From: Simon Davis
Sent: 13 November 2019 10:58
To: Planning Scanning
Subject: FW: BE/109/19/OUT Land East of Shripney Road

From: Simon Davis
Sent: 13 November 2019 10:57
To: [REDACTED]
Subject: RE: BE/109/19/OUT Land East of Shripney Road

TITLE: PROPOSED SITE ACCESS ARRANGEMENTS		
DATE: 05/06/19	DRAWN BY: BL	CHECKED: DT

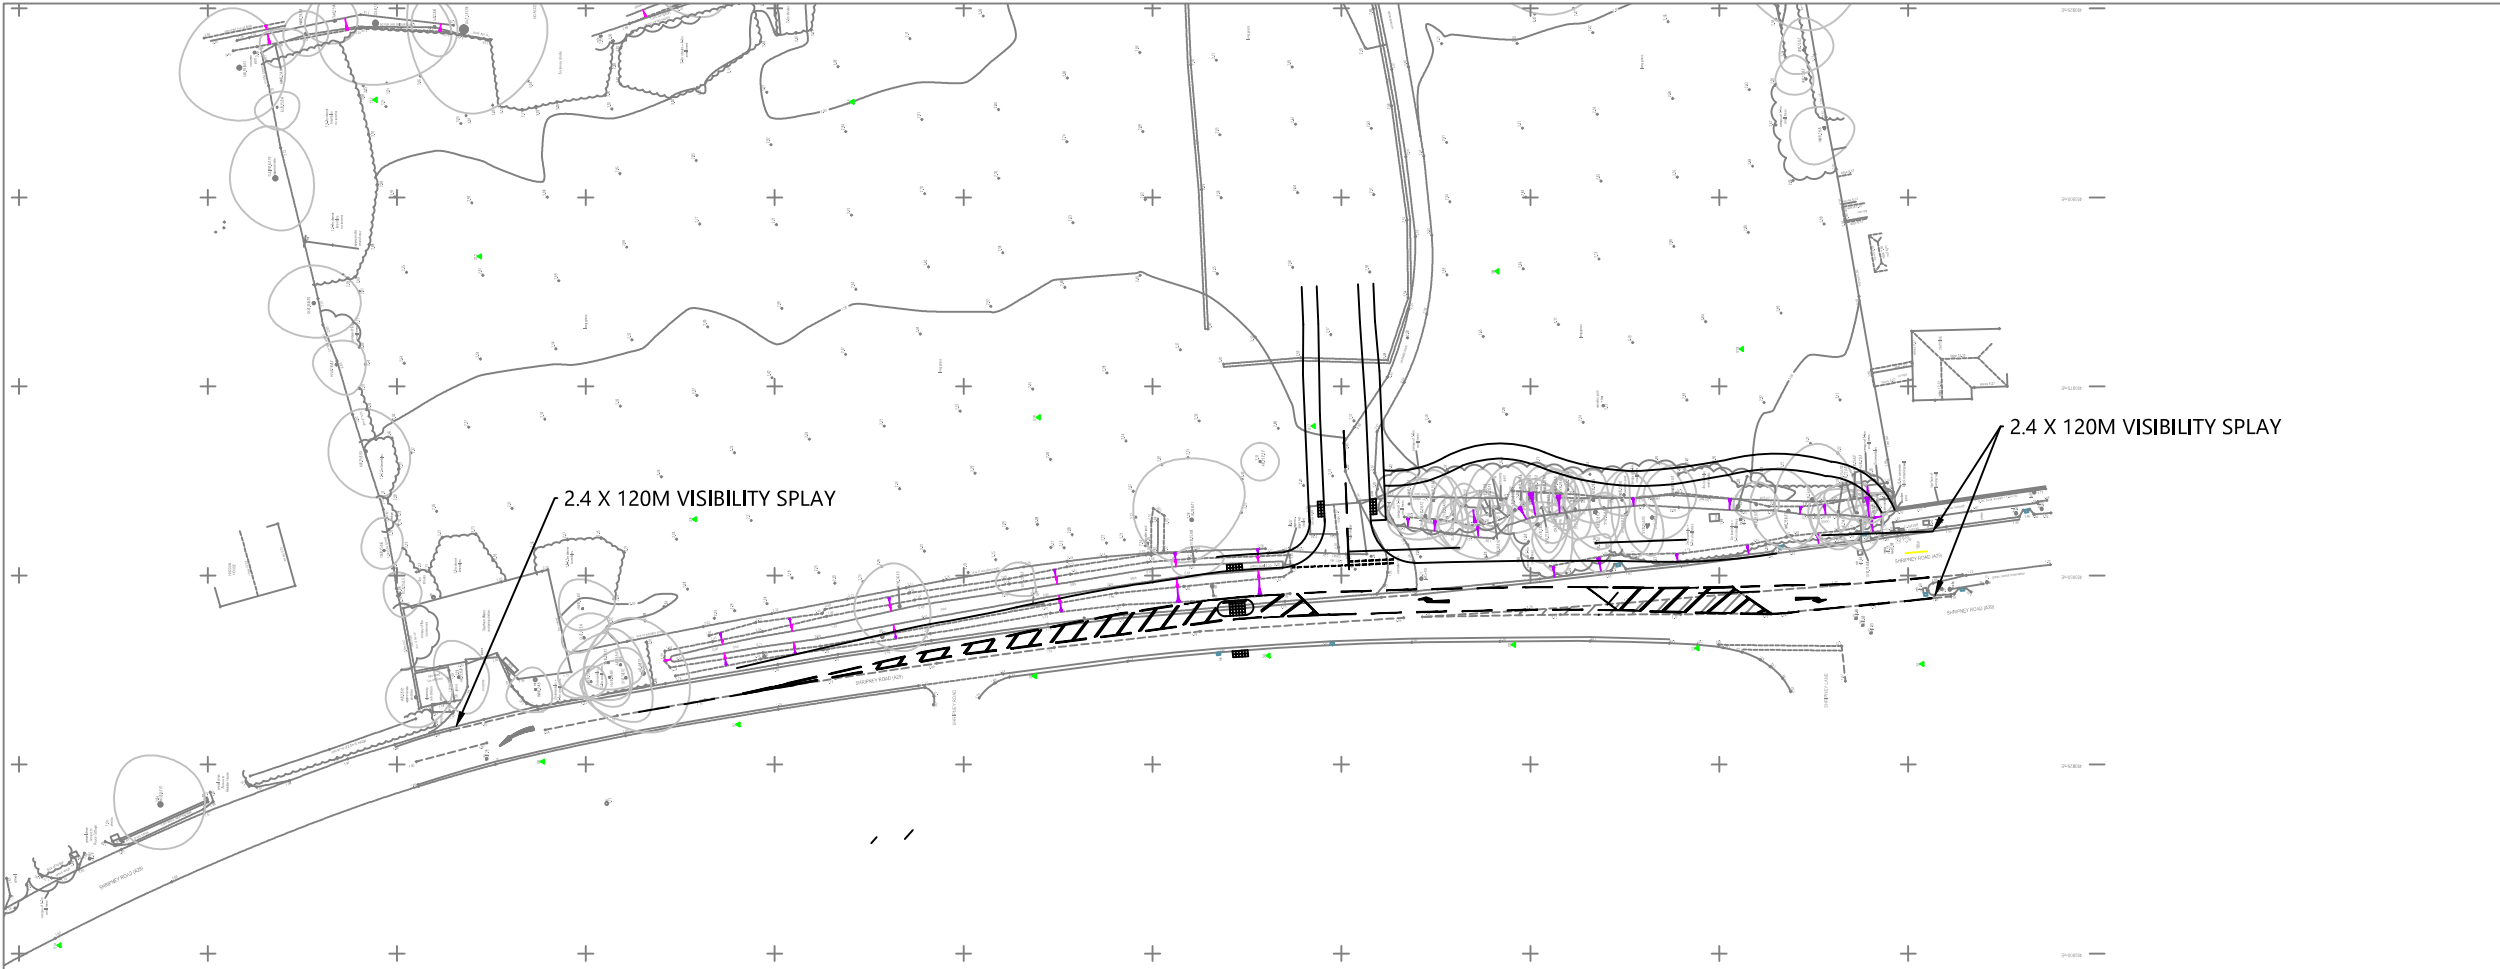
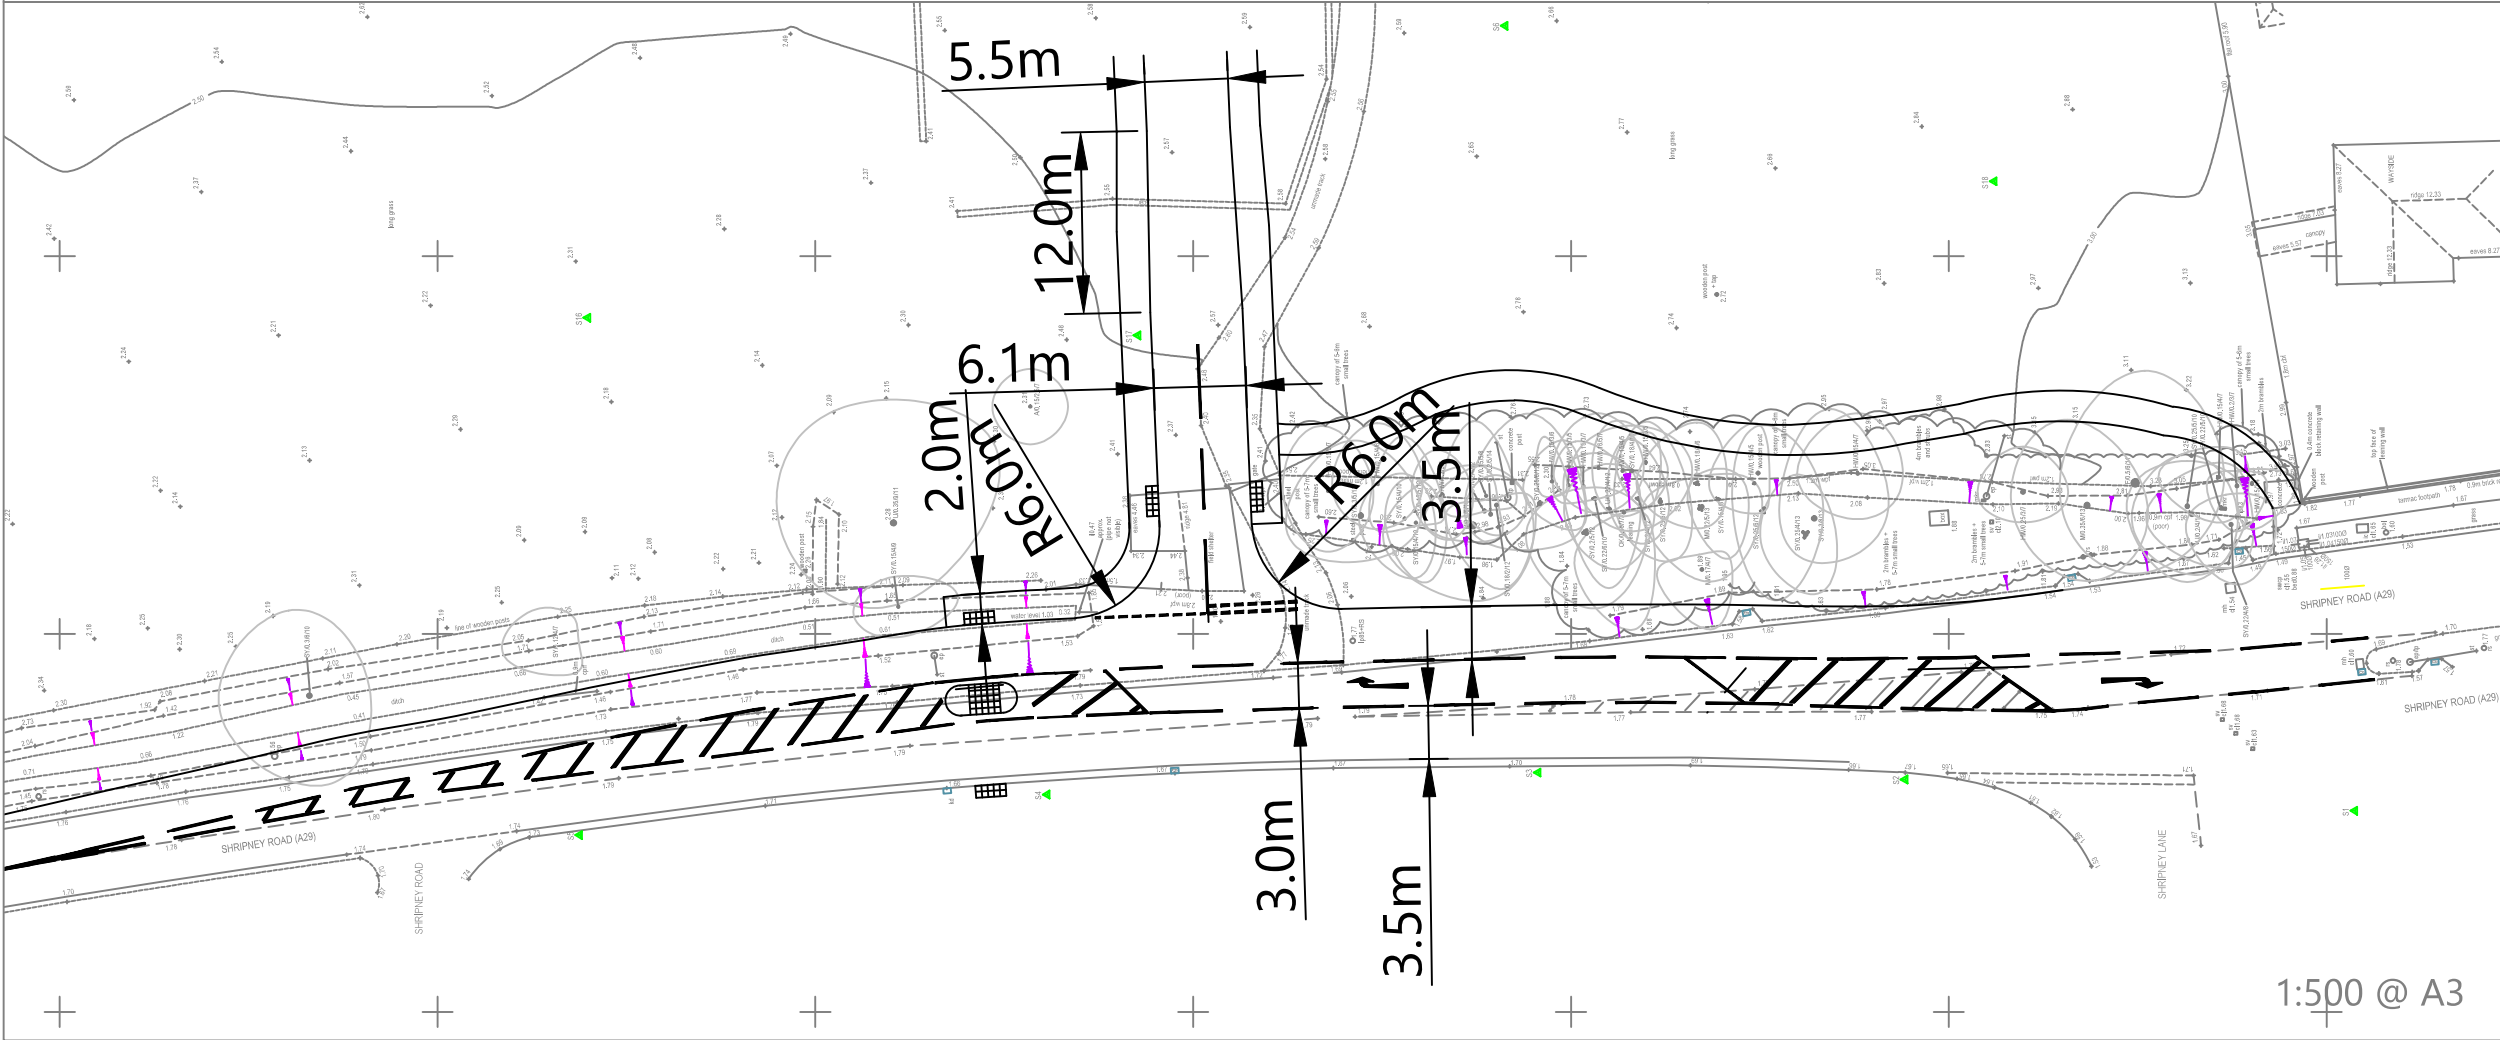
I need to make you aware of a couple of things with the application. Firstly, it appears as though your red edge does not include all of the land necessary to achieve the visibility splays at the site entrance. Therefore, we will require that article 13 notices are served on the affected land owners (WSCC will be one but there may be other affected land owners – please check this).
